I have raised a number of queries regarding East Park Energy [REDACTED] and feel that some major points that I have not seen covered, or explained in any detail in the discussions attended to date.

In my objections under the above reference I have raised many issues opposing this development, some picked up by many others also, but have a few specific items that I would appreciate specific answers to, these are :

Figure 2-4: Proposed Site Access

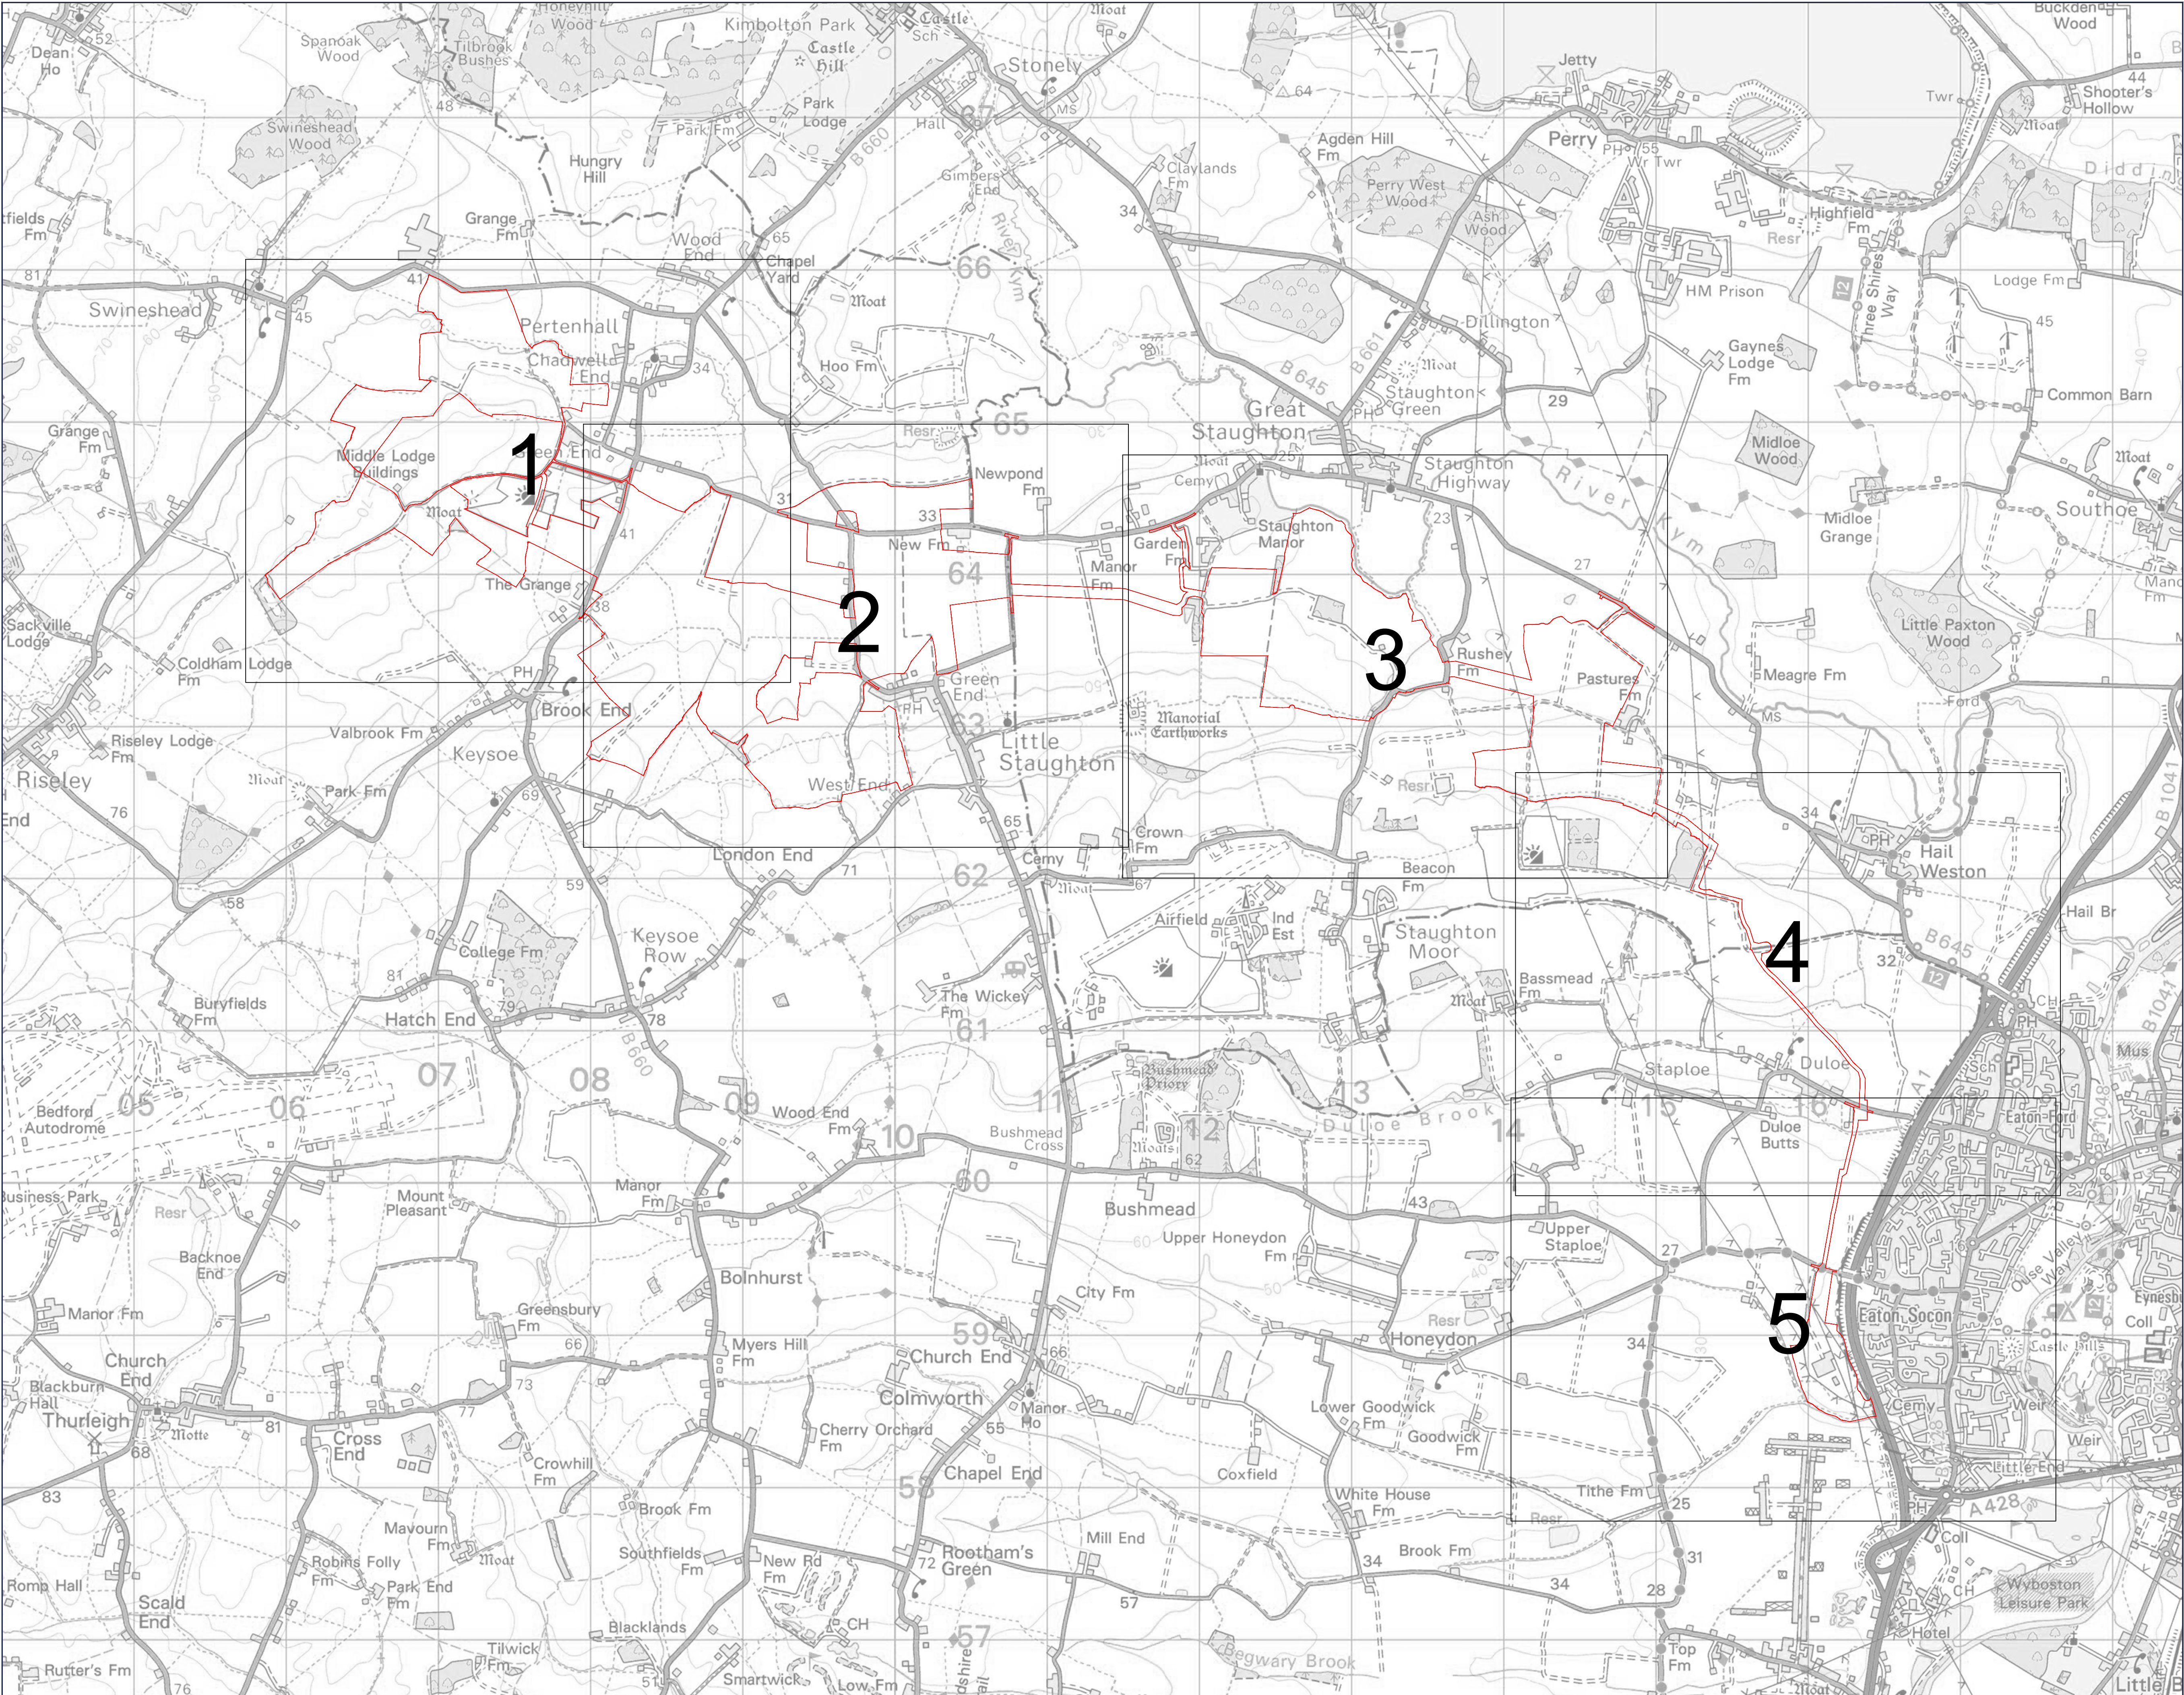
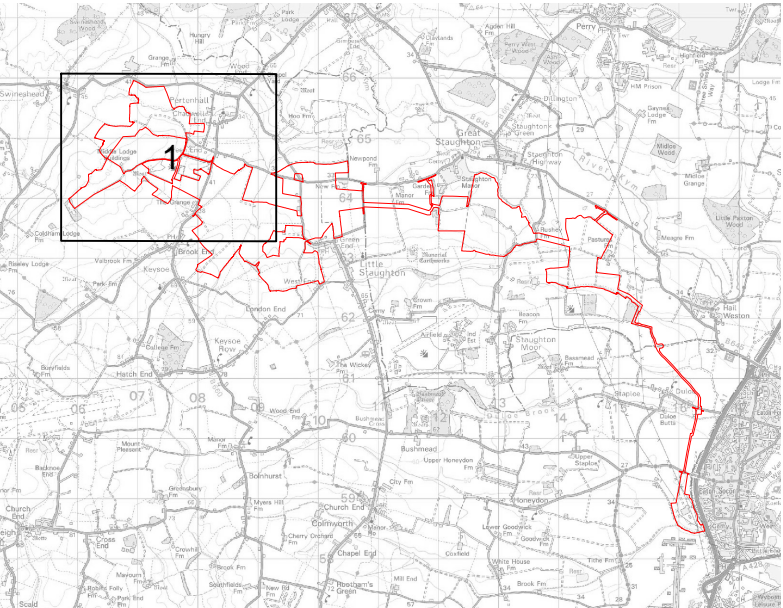
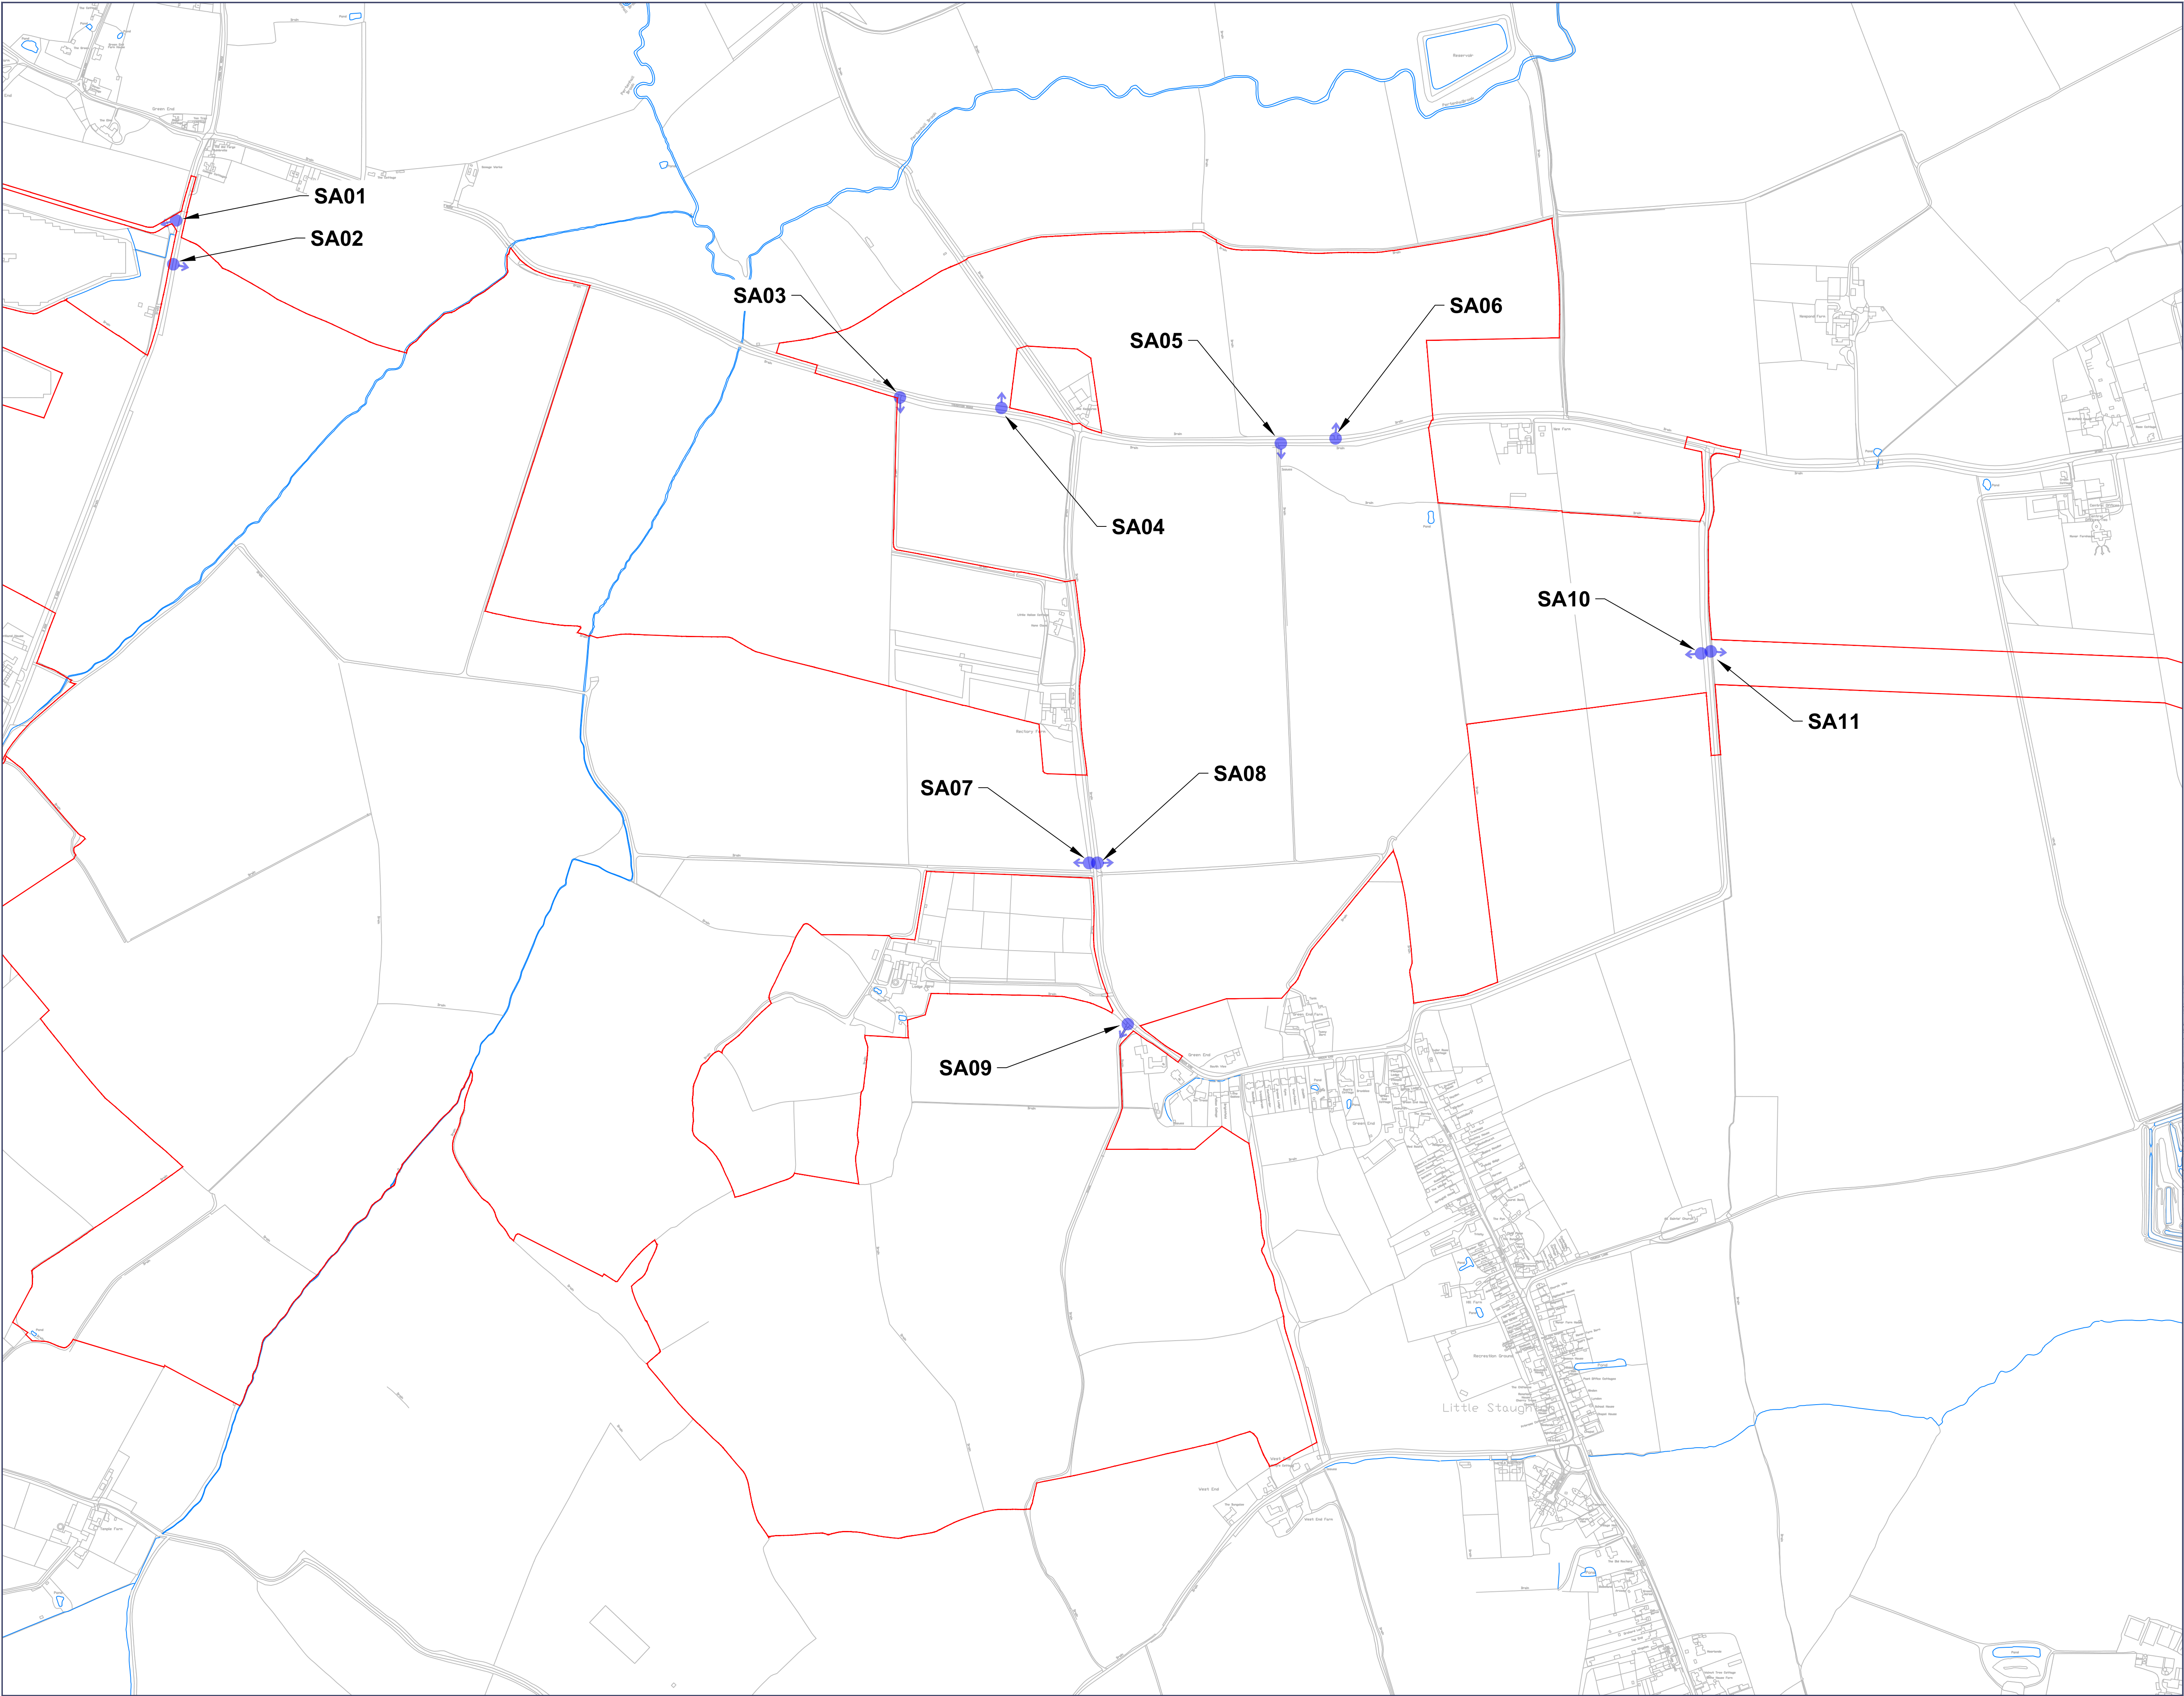
Access site point at Green end in Little Staughton (see pics in my objection), how can this be a sensible place on a bend right next to houses in Little Staughton be the right place, dangerous as on a bend and widening the road to accommodate will impact the village character and residents with volume of traffic crossing the road or queued up . Surely must be better places for it to be cited in many straighter bits of road and away from residents ?

What damage will be done when putting all the access points in to get this construction completed, how big will the access points be and what level of hedge. Tree screening will be damaged for all site access points, also what limitation on signs that are likely to be there for 3 years will be put in place ?
